**MASTER DEVELOPMENT DRAINAGE PLAN
AND PRELIMINARY DRAINAGE REPORT FOR
WATERBURY FILINGS NO. 1 & 2
EL PASO COUNTY, COLORADO**

**PCD FILE NO:
PUDSP-21-005**

SEPTEMBER 2021

WATERBURY FILING 1 & 2
EXISTING MDDP DRAINAGE MAP 1
OFFSITE MAP

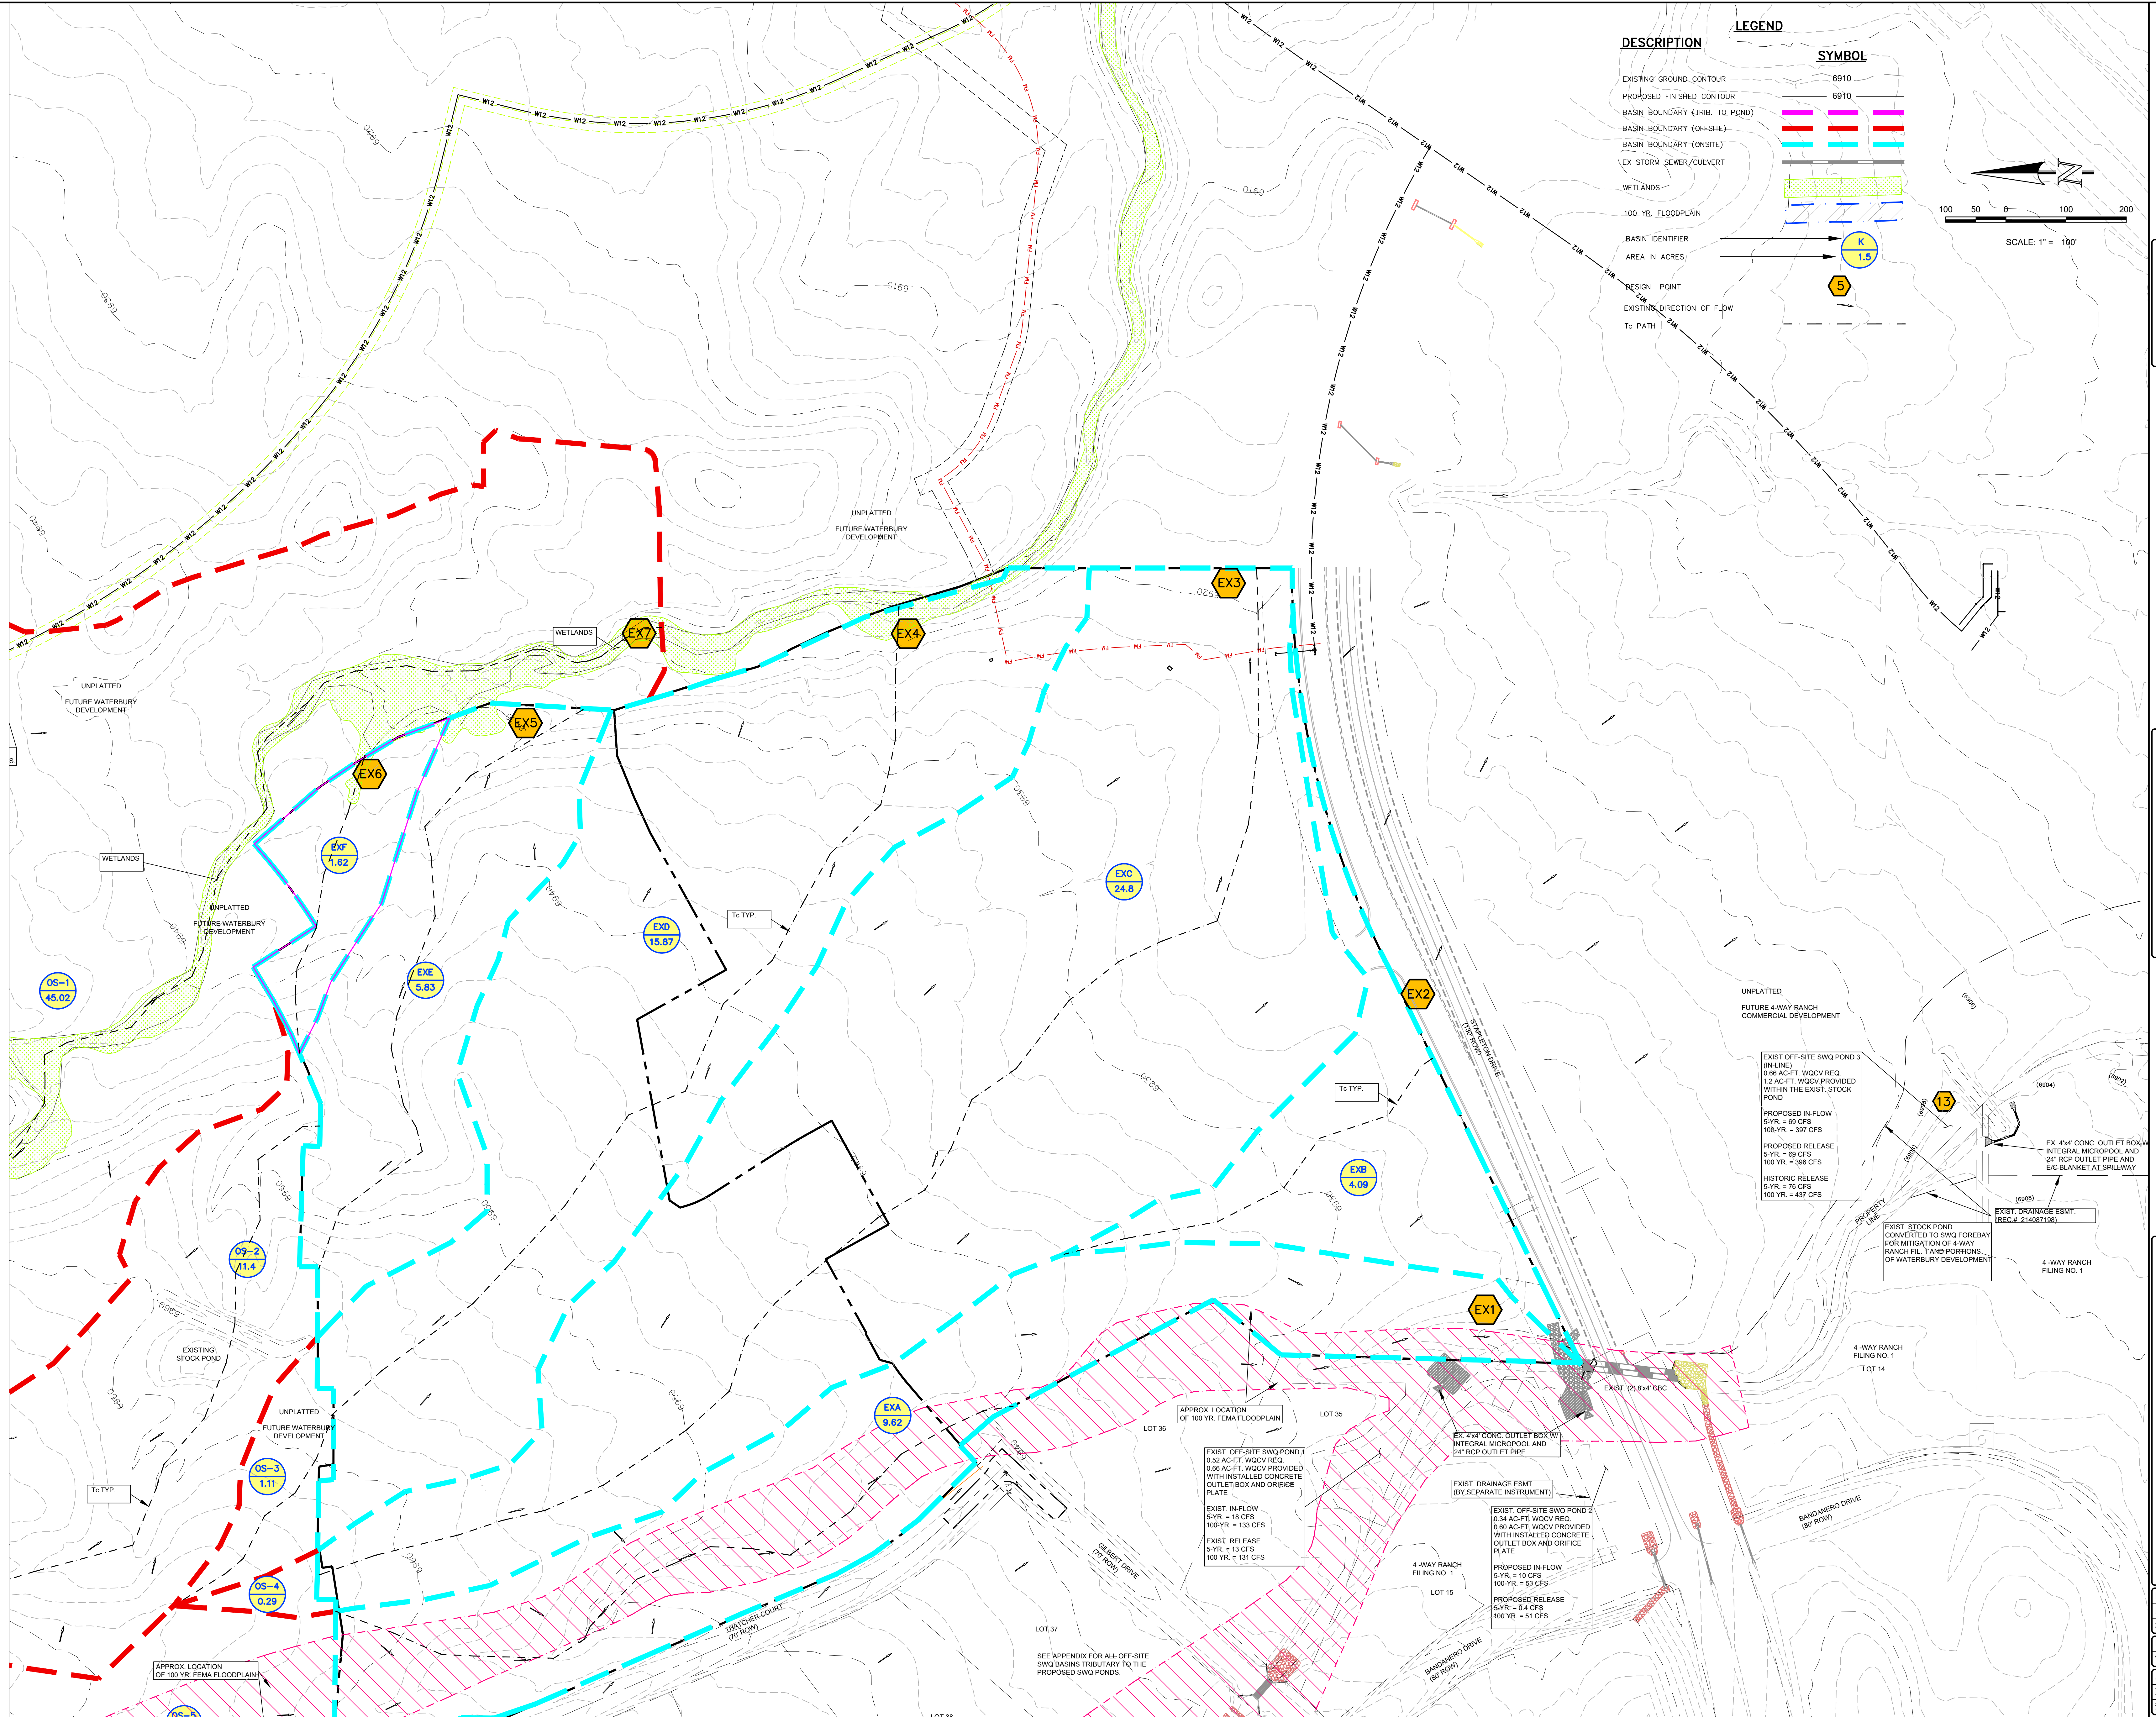
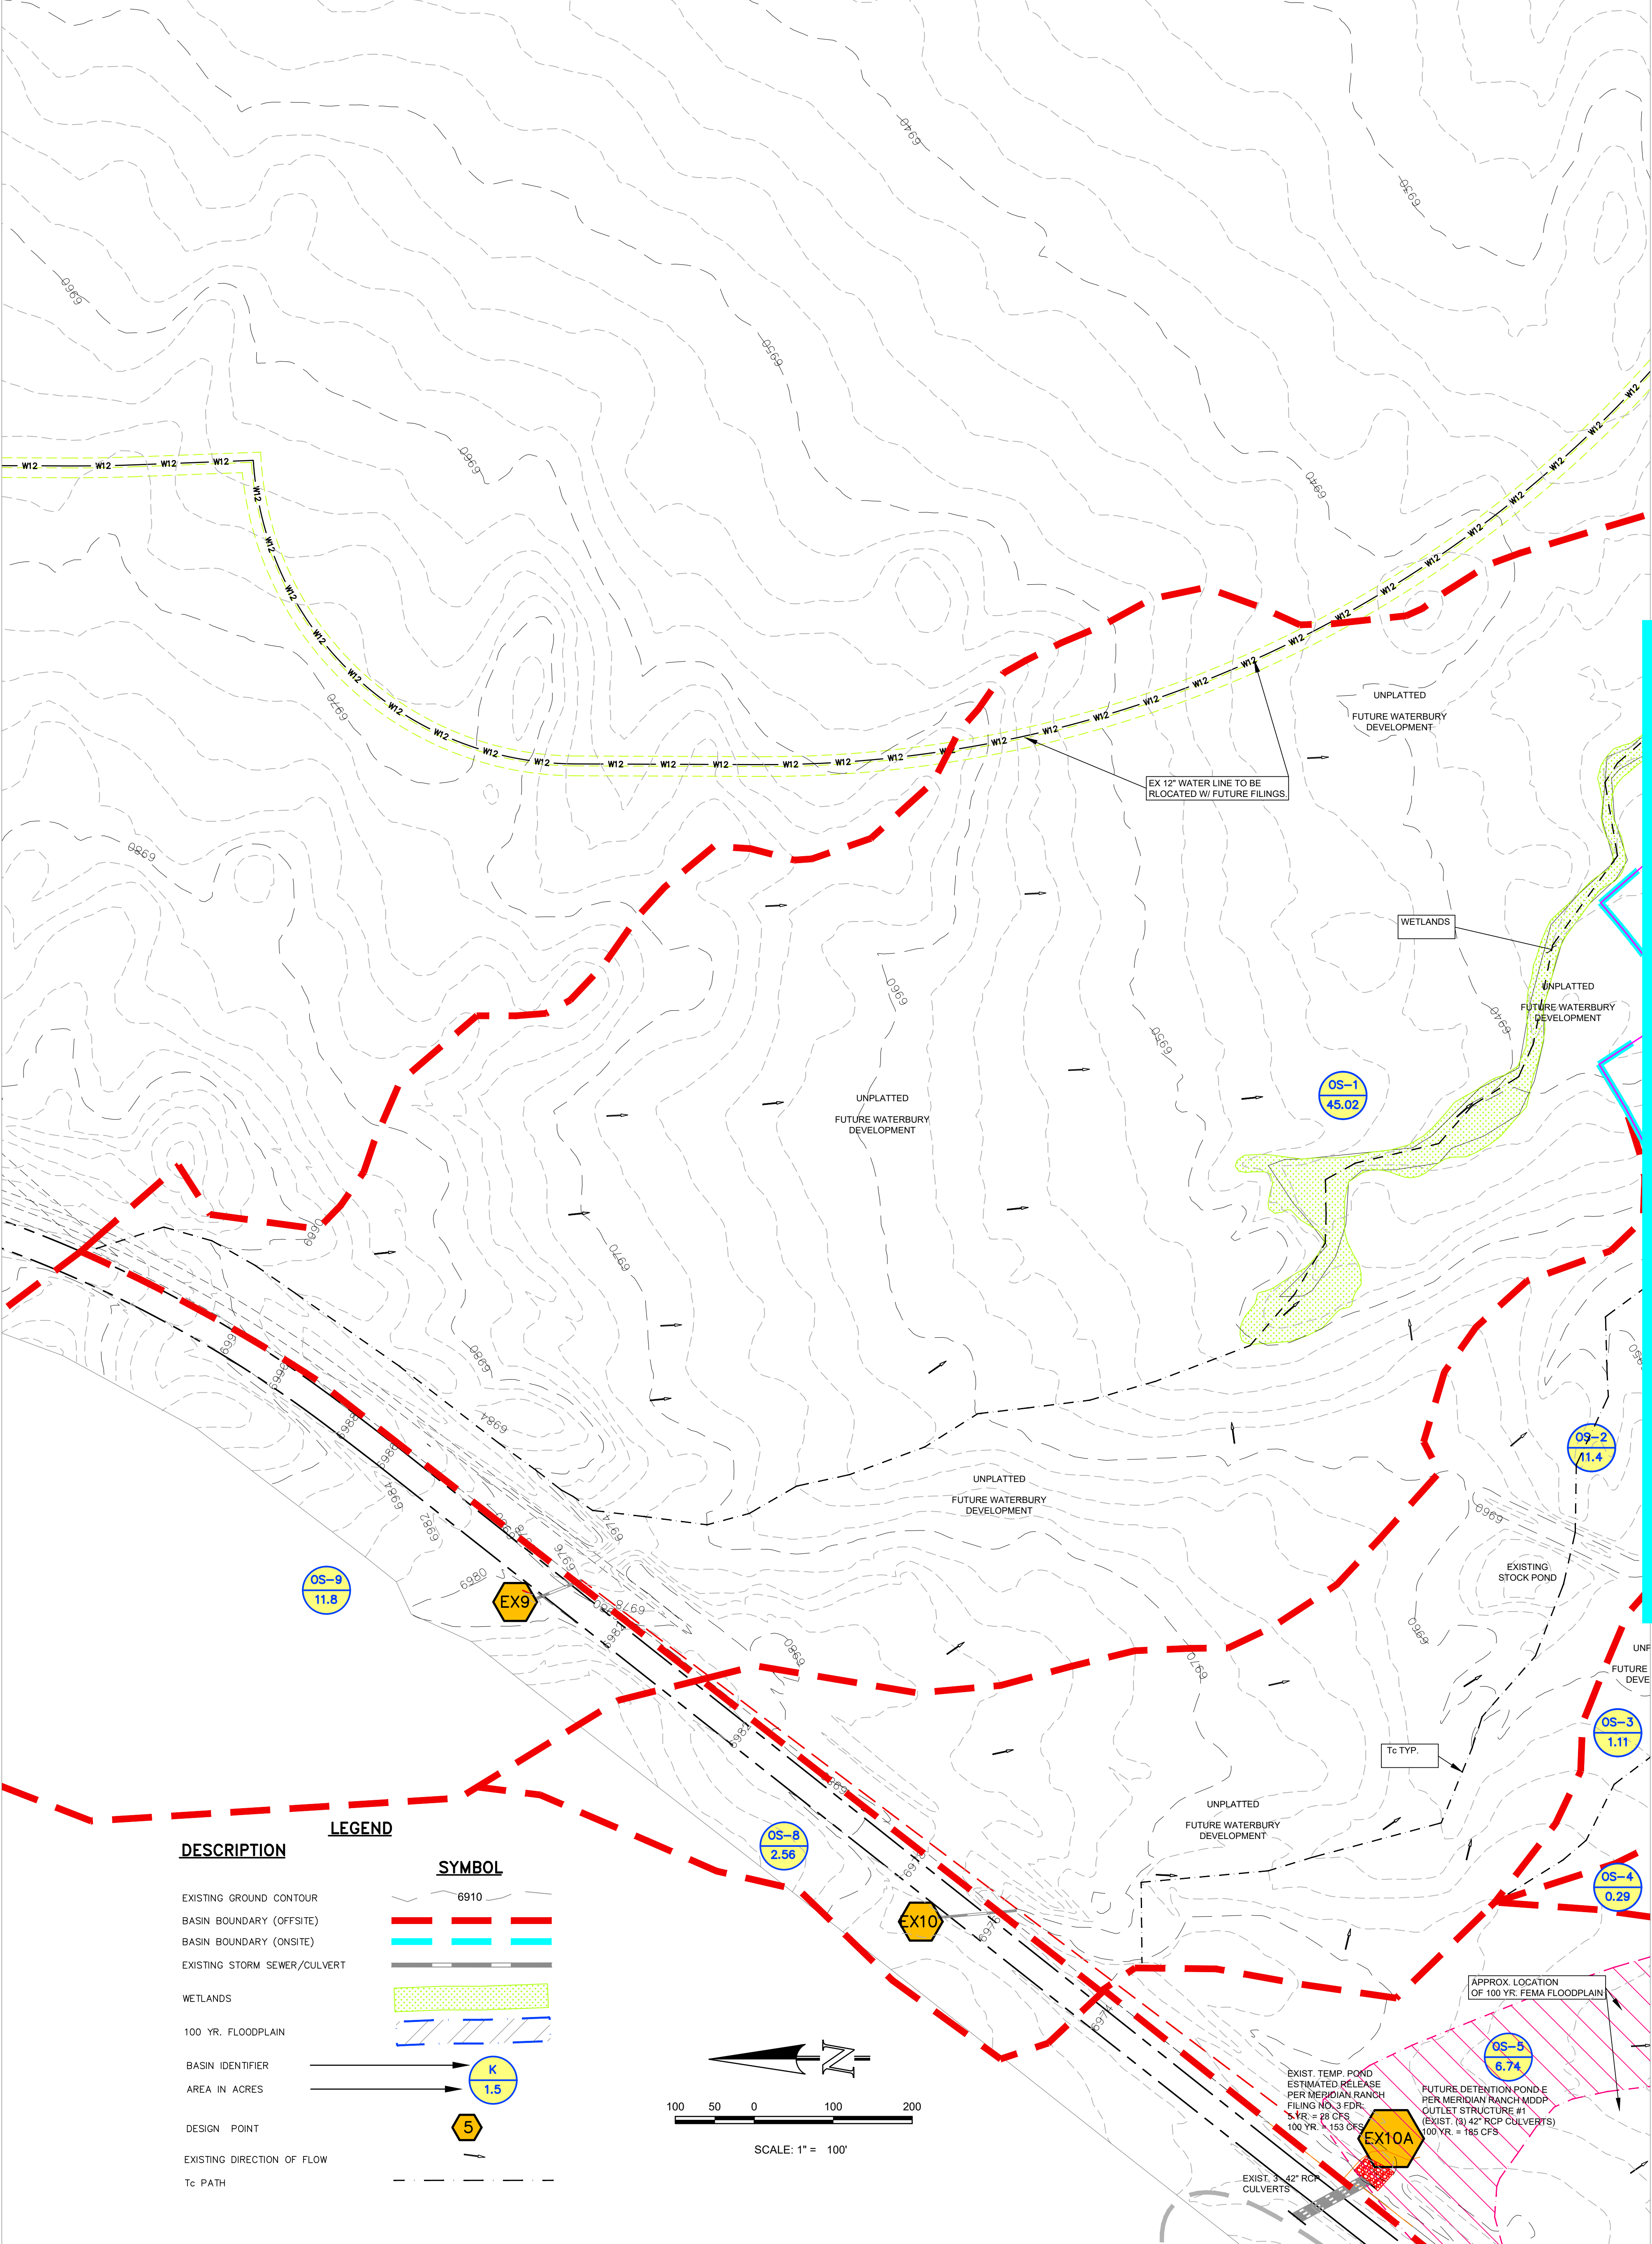
Drainage map calls out 8 x 4 boxes, Please confirm which dimensions are height and width.

Existing surface routing spreadsheet has Q_{100} of 180 cfs.

Existing surface routing spreadsheet has Q_{100} of 2 cfs.

Per spreadsheet, these
flows at DP EX7 only
account for Basins OS-1,
OS-9 & EXF

180 is correct

CORRECTED
BASINS AND
THE FLOWS
CHANGED
